Our ref: STH11/00145/05 and STH11/00145/06
Contact: Andrew Lissenden 0418 962 703
Your ref: MP10_0144 Mod 1 and MP10_0108 Mod 1

28 October 2021

APPLICATION TO MODIFY CONCEPT PLAN (MP10_0144 MOD 1) AND PROJECT APPROVAL (MP 10_0108 MOD 1) – SHOALHAVEN STARCHES GAS PIPELINE PROJECT - INCREASE IN PIPELINE DIAMETER AND ASSOCIATED WORKS - PUBLIC AGENCY CONSULTATION

Figure 2 - Pipeline Route

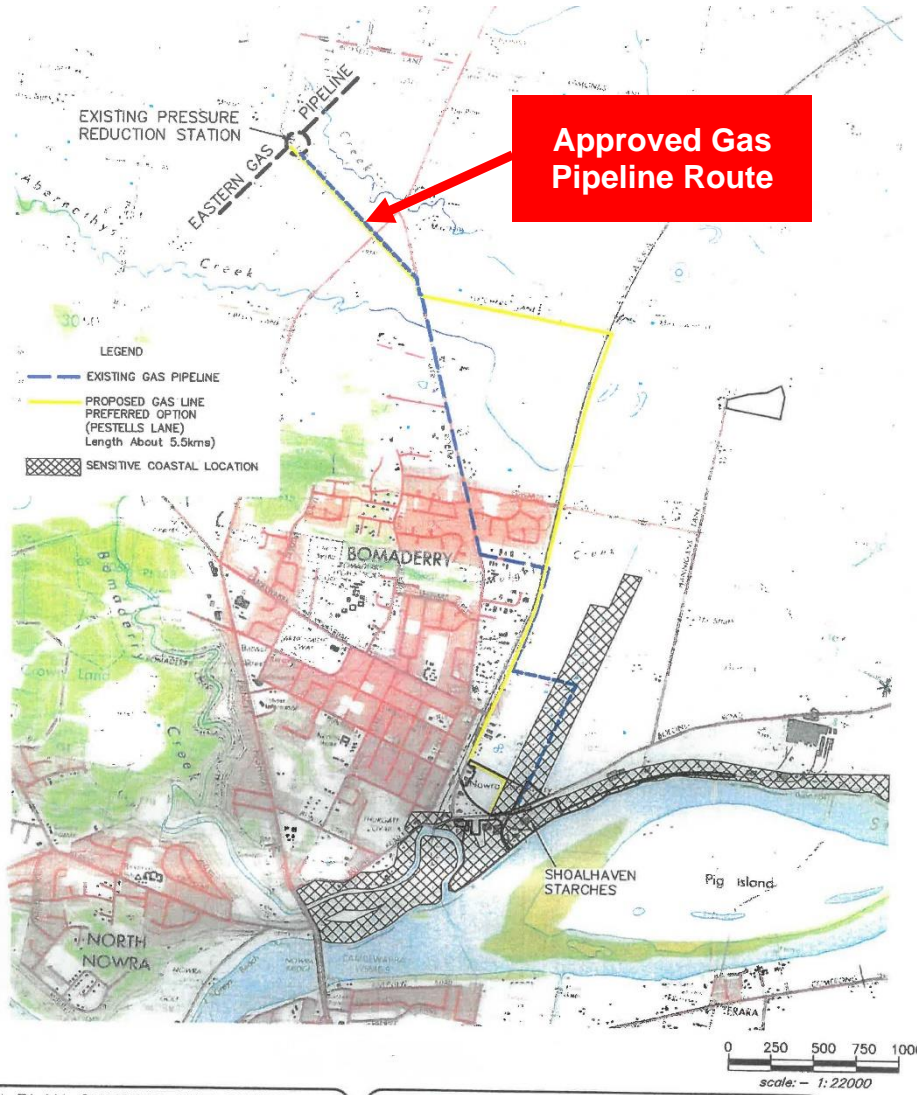
- the key state classified road is the Princes Highway which the gas pipeline crosses (southern side of Pestells Lane). The Princes Highway is currently subject to upgrade works between Berry and Bomaderry;

Shoalhaven Starches accept that longitudinal trenching is to be at a minimum of 0.6m whilst in the road reserve of the Princes Highway, as close to the road boundary as possible and not within 3.0m of the road formation or drainage structures/channels.

Underboring of the Princes Highway shall ensure that the pipe is located a minimum of 1.5m below the open drainage structure/channel on the western side. Before commencement of works within the Princes Highway road reserve discussions shall be had with the Berry to Bomaderry - Princes Highway upgrade project team (Jason Llyod (Project Manager/Engineer) – Ph: 8874 6834 or 0418 299 379 Email: Jason.Lloyd2@transport.nsw.gov.au).
